Subject: FW: Planning Consultation on: AL/59/21/DOC

Condition 10- surface water drainage design

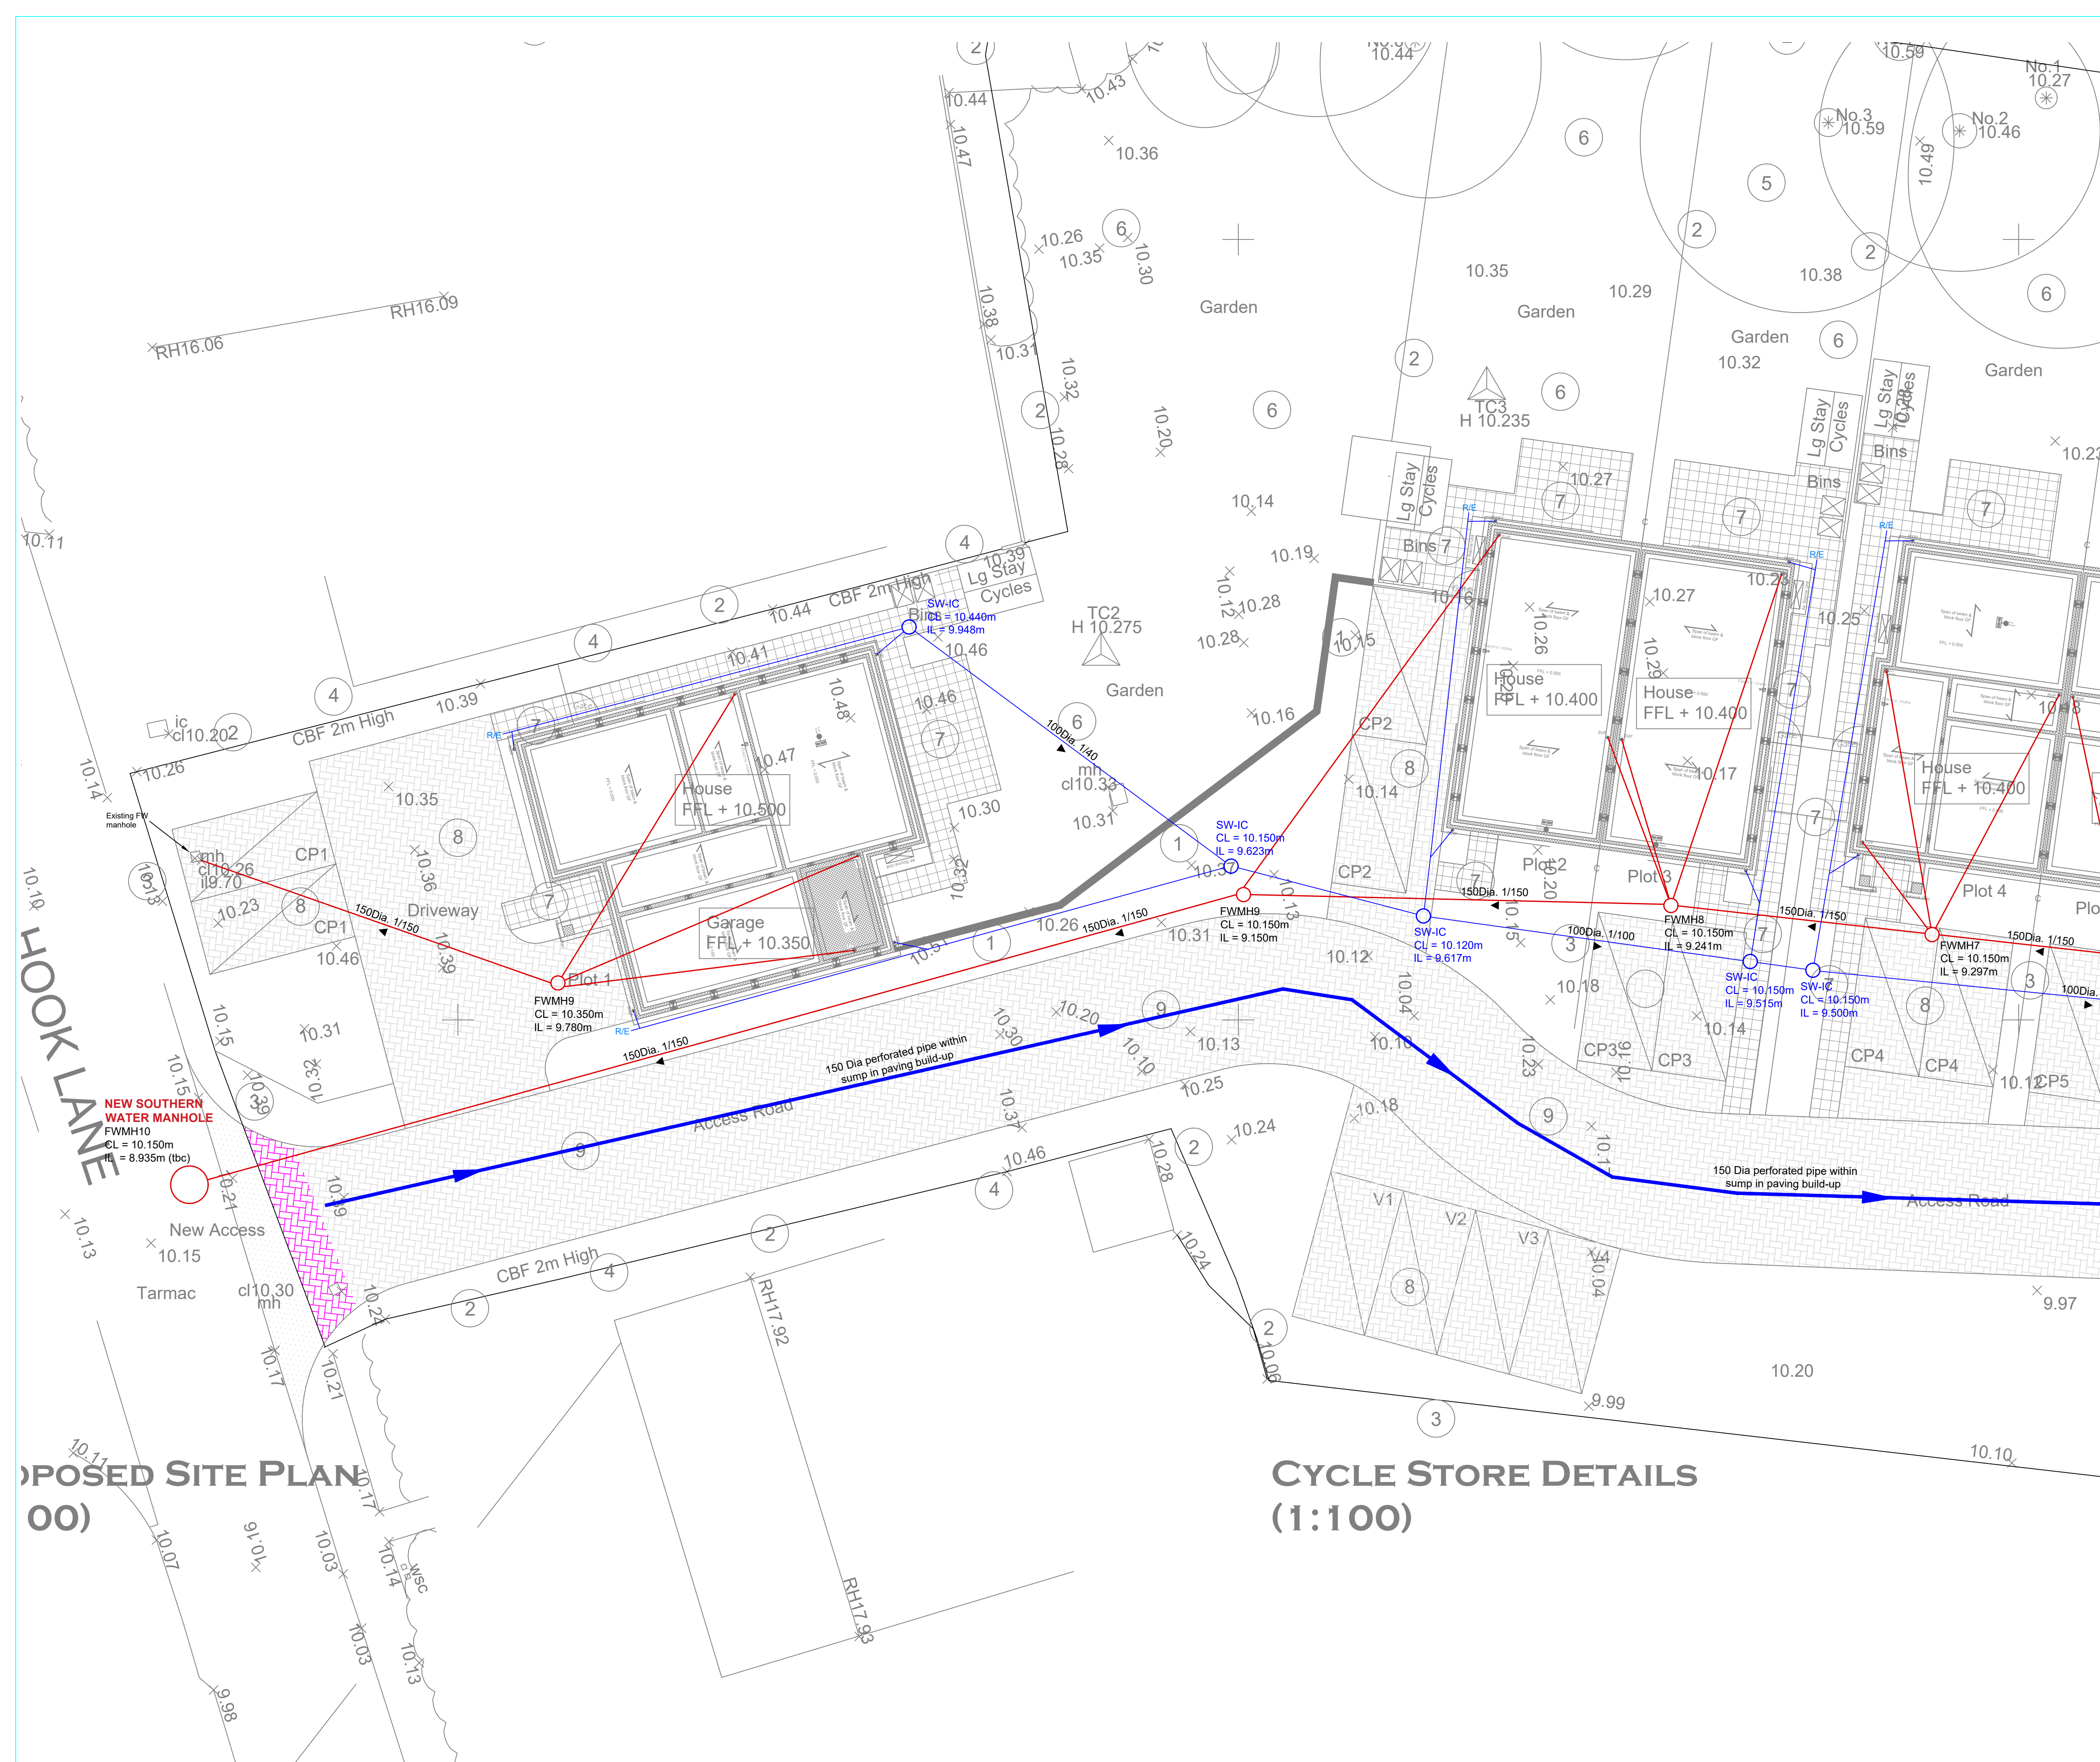
We note that it is proposed to pump surface water. This is not supported as per SuDS policy 3 of the adopted West Sussex Lead Local Flood Authority Policy on the management of surface water. The ditch system needs to be further investigated to determine the true invert level. A shallow gravity system must be fully explored.

The application is missing information such as calculations and testing results to support the design. Due to the amount of information that is missing and lack of policy compliance of the proposed scheme we would support a refusal of this application. We would strongly recommend that the applicant reviews and completes our surface water drainage checklist with a revised application, the checklist can be found here: [Supplementary Requirements for Surface Water Drainage Proposals | Arun District Council](#)

Further information on the existing ditch must be provided. Evidence of land drainage consent must also be supplied with this application. This information has not been provided.

SECTION ELEVATION OF PUMP CHAMBER
(THOUGH MAY VARY DEPENDING ON CHOSEN PUMP CHAMBER SUPPLIER)

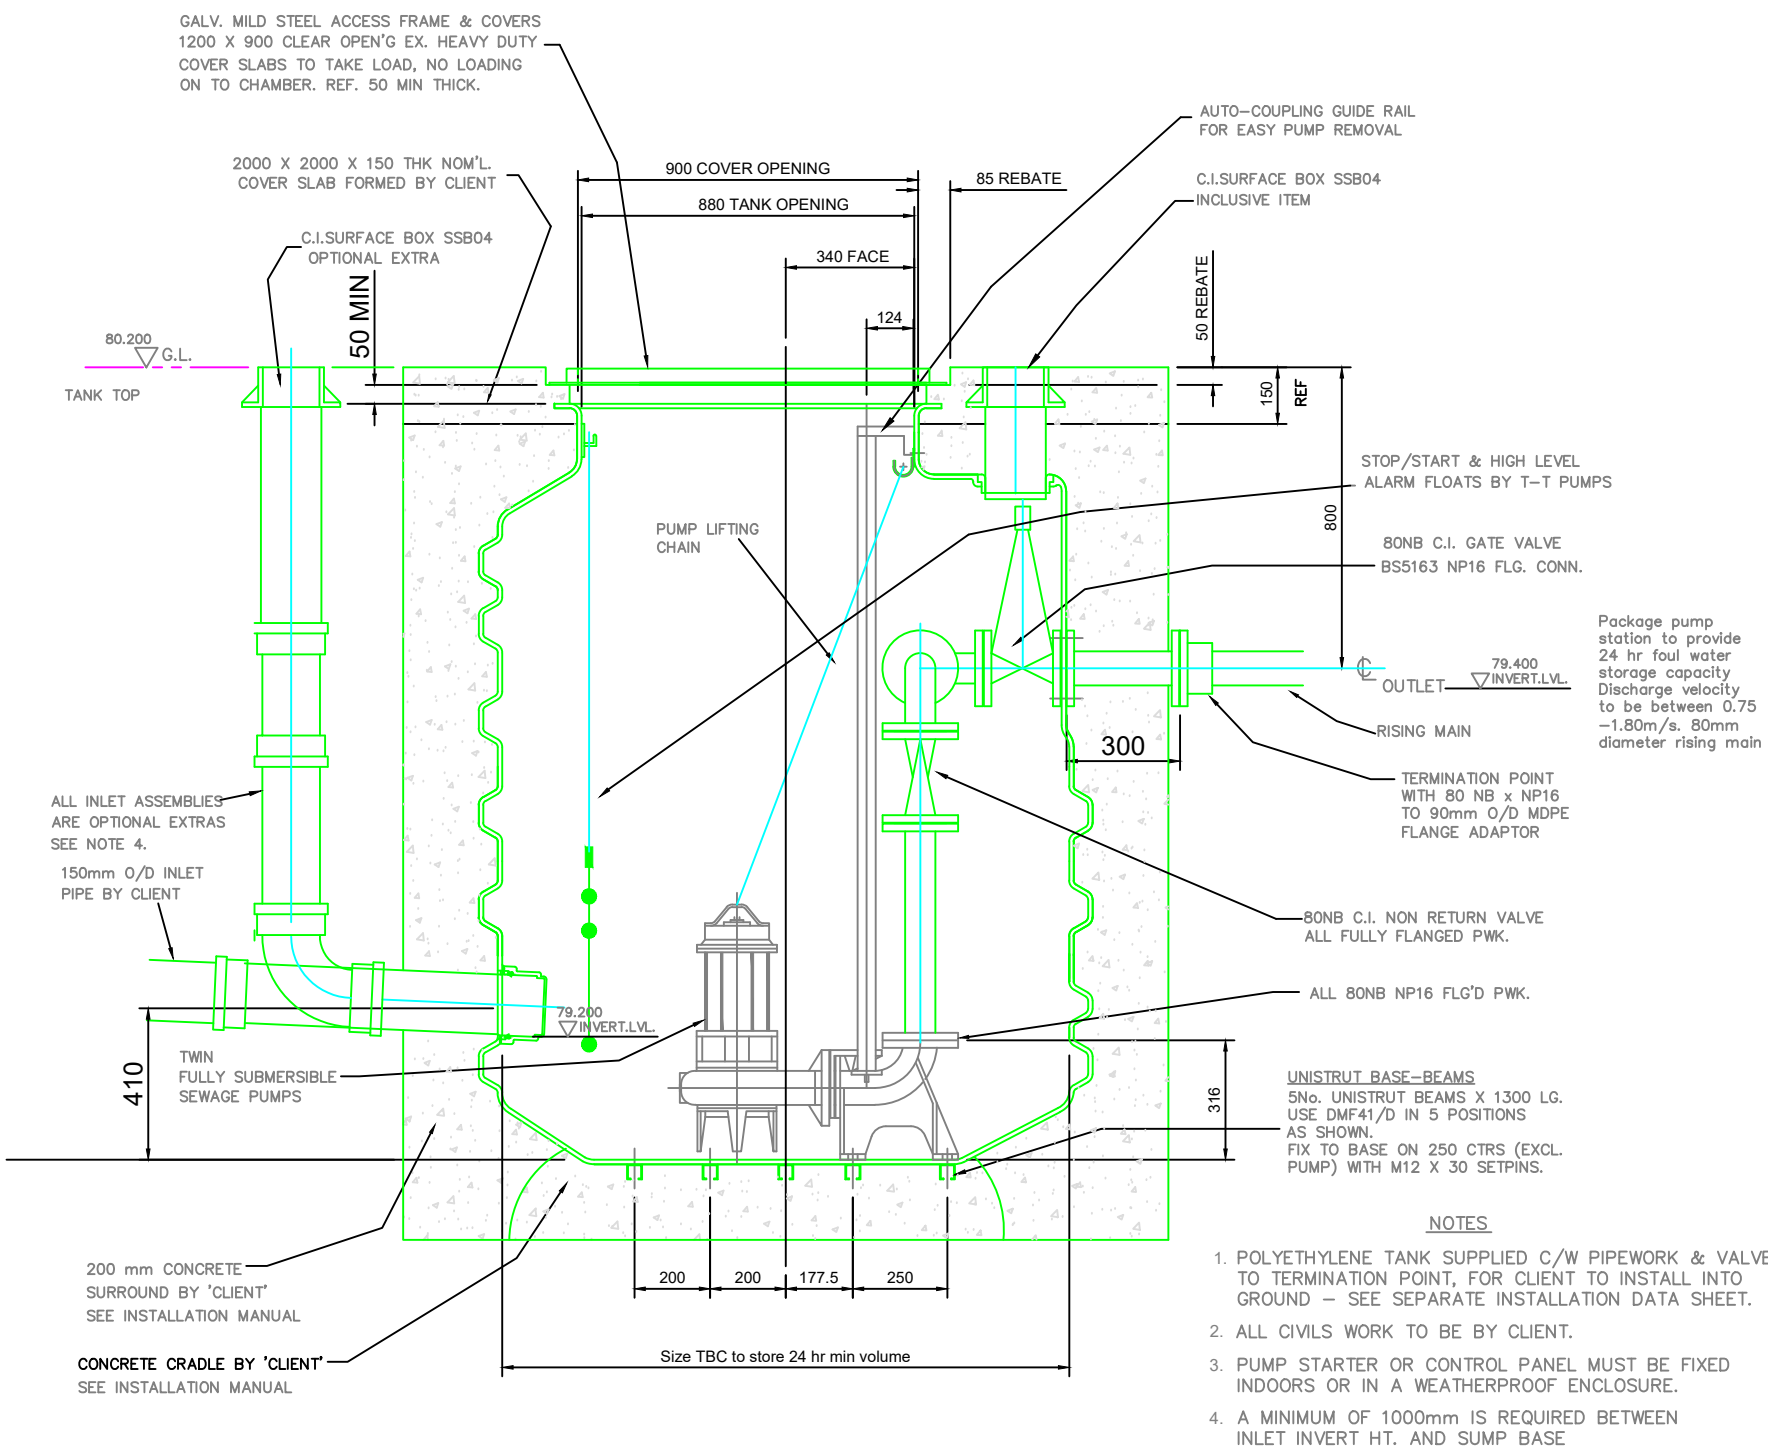
- Pumping is not sustainable and gravity options must be fully explored;
- The applicant should consider the significant use of permeable paving and other shallow features to convey and store water across the site, whilst minimising the use of pipework;
- Barratt David Wilson have recently undertaken works to the boundary ditch and installed a positive outfall from it into their onsite drainage system;
- The applicant should fully survey the ditch and its outfall, as this will impact any design;
- It may be necessary for the applicant to undertake further works to this ditch to reduce bed levels where possible, in order to aid a gravity solution;
